An Coimisiun Pleanála,
64 Marlborough Street,
Dublin 1,
DOI V902

09/07/2026.

Reference: Submission of Planning for Proposed Littleton Wind Farm. B N.M and SSE.

TITLE: Substation Noise Sensitive Locations	
PROJECT: Litleton Wind Farm	
FIGURE NO:	11.4
CLIENT:	Litleton Wind Farm DAC
SCALE:	1:7,500
REVISION:	0
DATE:	05/03/2026
PAGE SIZE:	A3

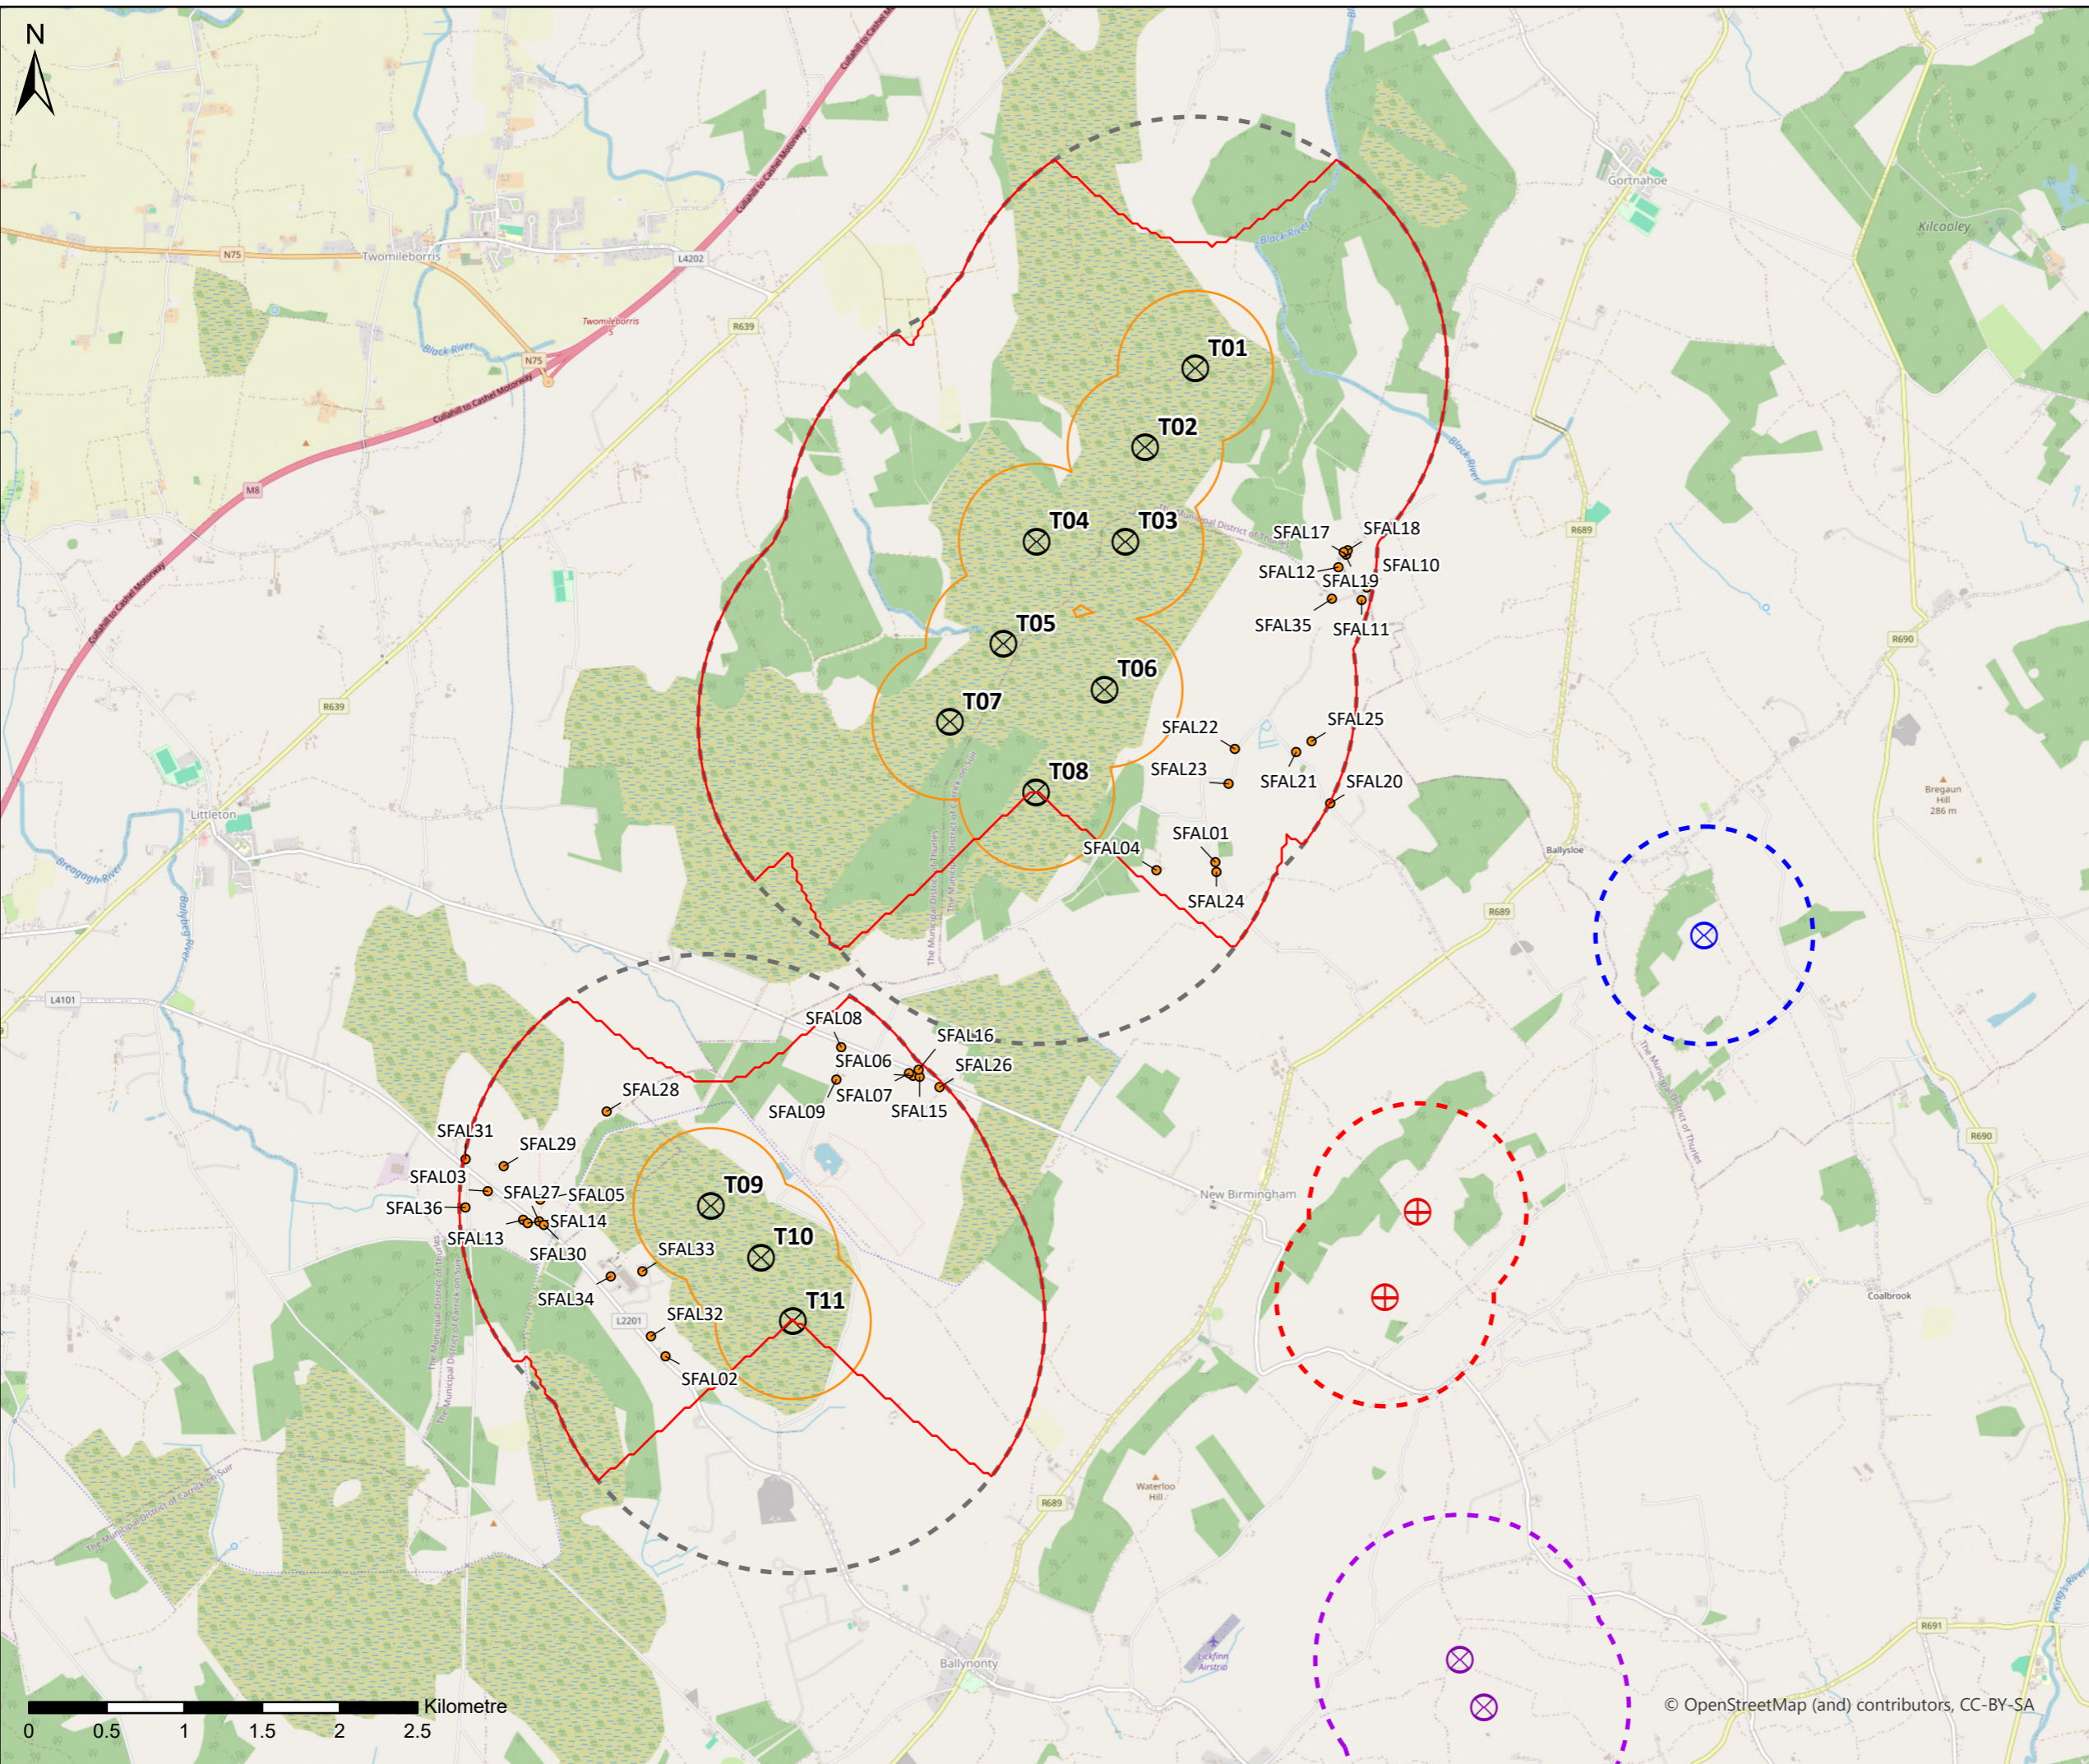
9. Commercial Businesses beside the borrow pit: These businesses are not listed on the map. Figure No. 11.4. Why is this so? This seems to be a very large discrepancy. Business No. 1: Haydens Haylage, in business since 1997, producing 20,000 bales per year. Business No. 2: Haydens Plant and Agri Limited. Registered addresses, Longfordpass, Thurles, Co. Tipperary.
